### STAFF REPORT BIG BUCK RIDGE PRELIMINARY PLAT LP-07-00040

TO: Kittitas County Hearing Examiner  
FROM: Kittitas County Community Development Services Staff  
RE: Big Buck Ridge Preliminary Performance Based Cluster Plat (LP-07-00040) **REVISED**  
**CONDITIONS OF APPROVAL**  
DATE: April 23, 2013

PROJECT#	SHEET: 2
2007-389	OF: 3

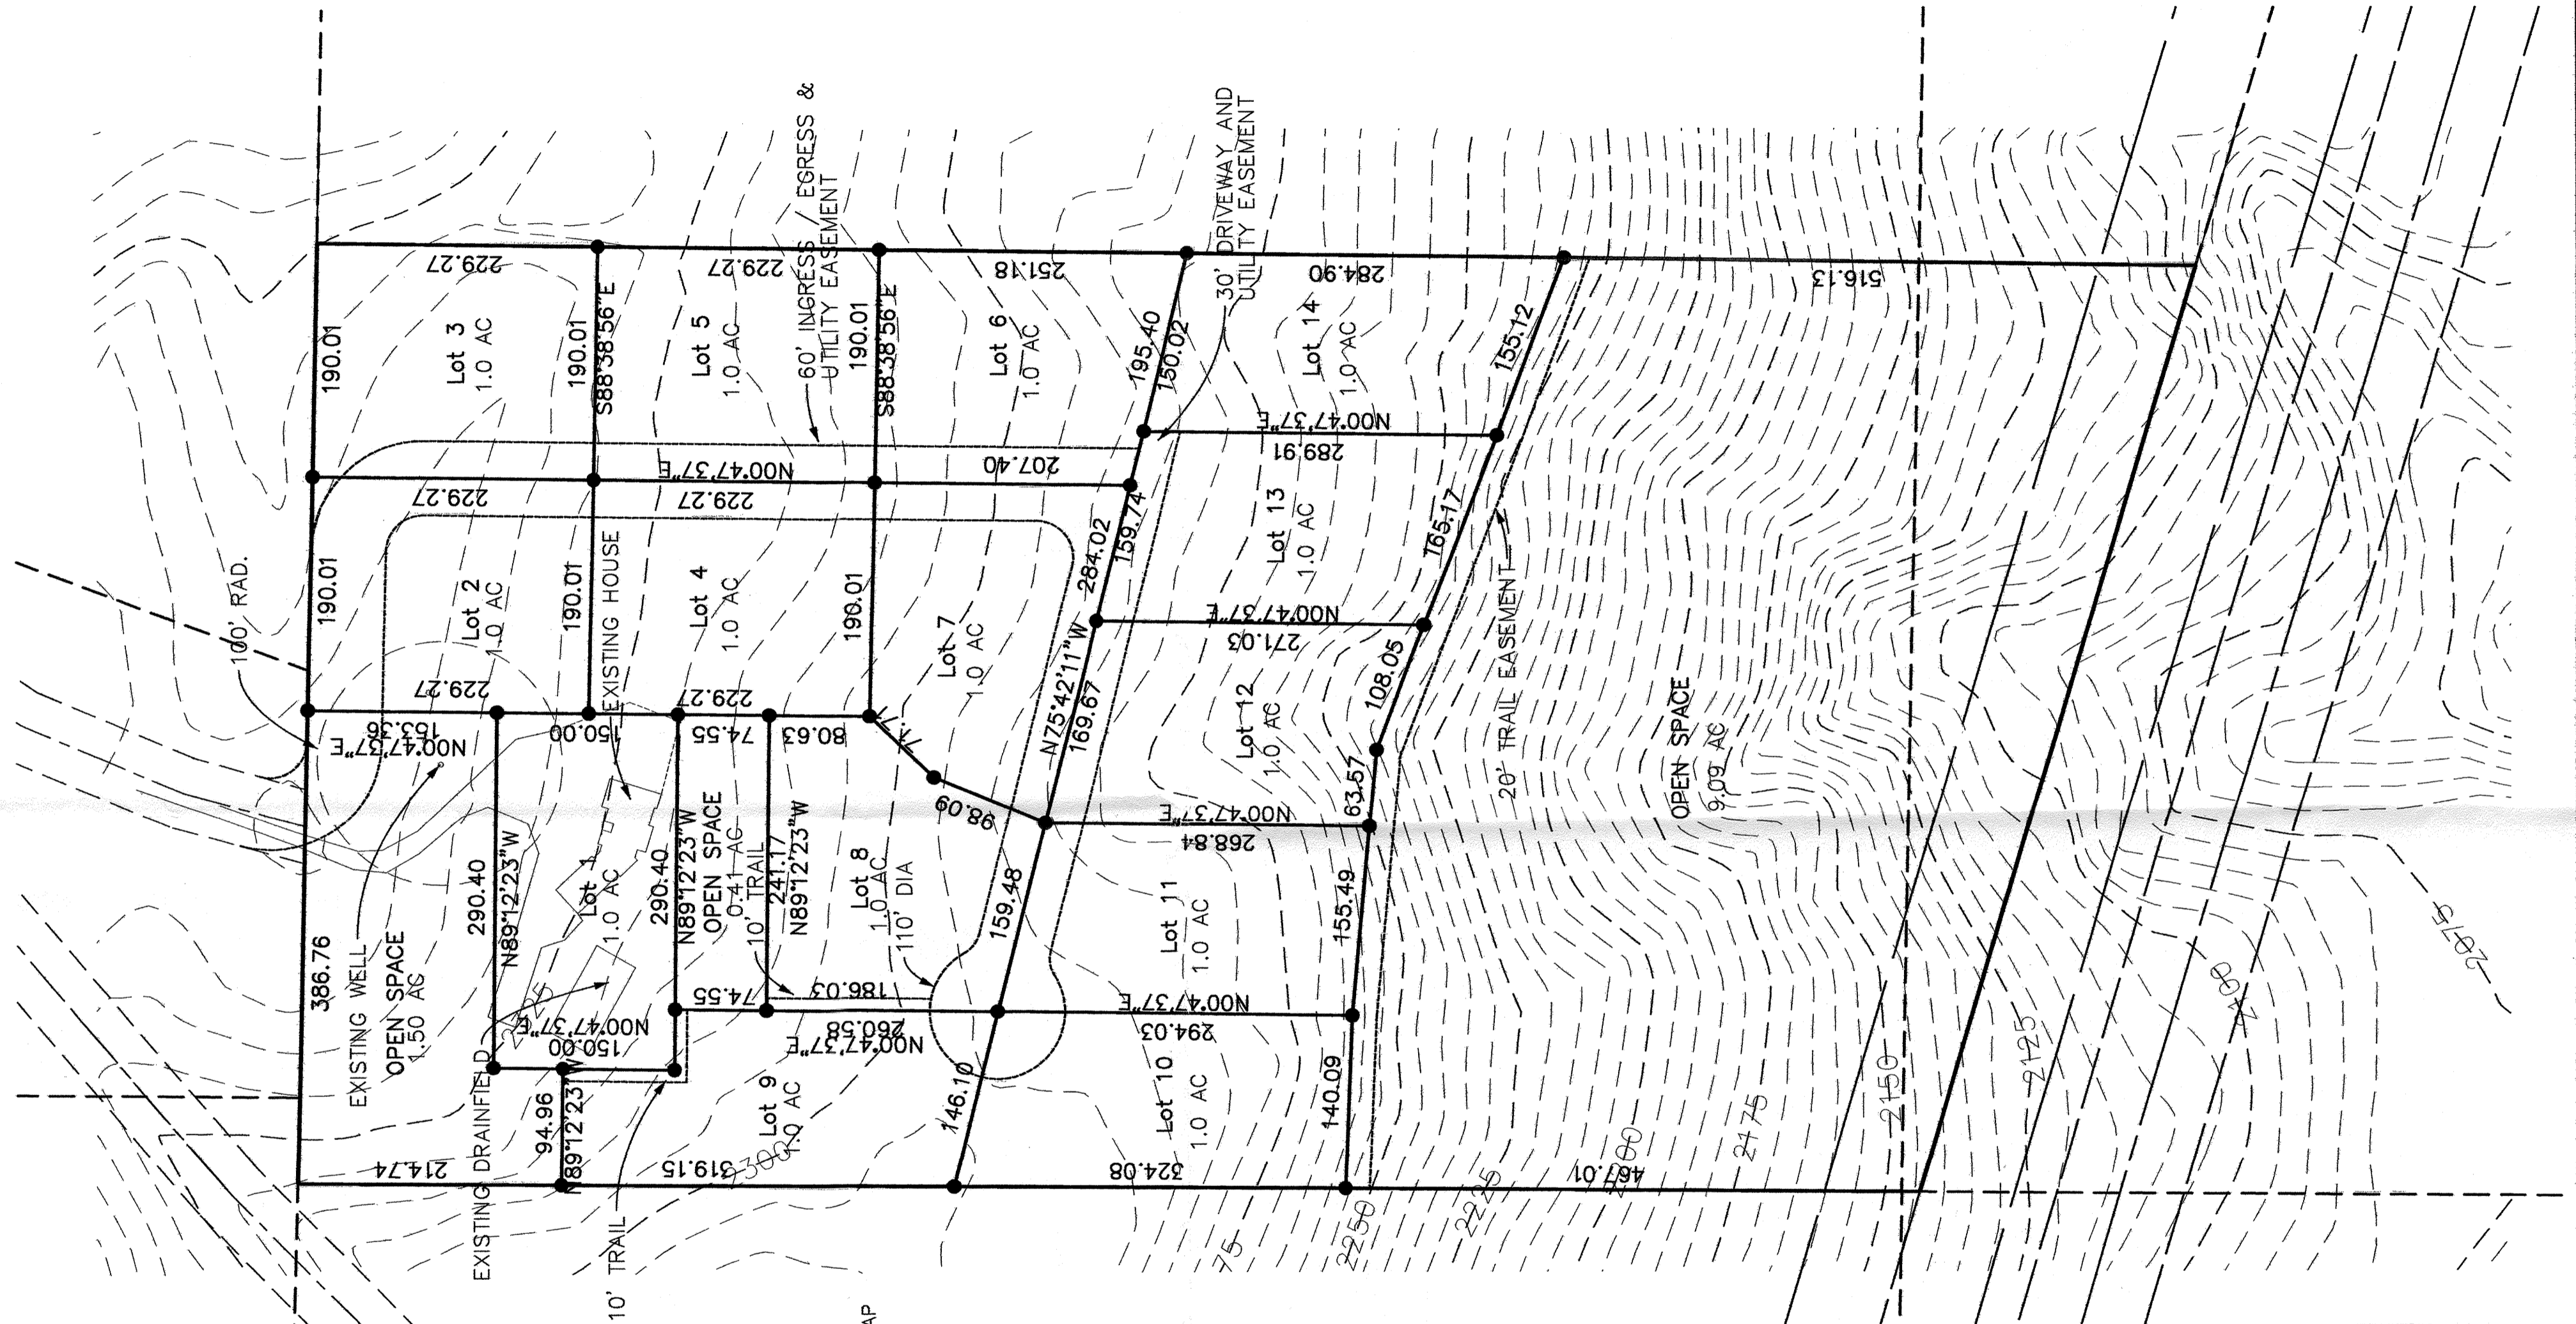
- 35) An internal looped trail shall be bonded for or constructed in conjunction with the plat infrastructure. It shall run parallel with, but in addition to, the entire length of the private road servicing the plat to the 10 foot easement depicted on the west lot line of lot 8; then north across the .41 acre open space tract where it will connect with the 10 foot trail easement along the north and west lot lines of lot 1 to the 1.50 acre open space tract; then north and east back to the private road easement. This active recreation trail shall be constructed of an approved hard surface to accommodate wheeled traffic and utilize standards in conformance with the ICC

- 36) Open space tracts shall be labeled with a unique identifier.
- 37) The face of the plat will depict accurate calculations for open space tracts which do not include areas covered by road easement or driveway, well head protection areas, utility right of way, critical area or region encumbered by other federal, state, or local jurisdiction (as per ordinance 2007-22).
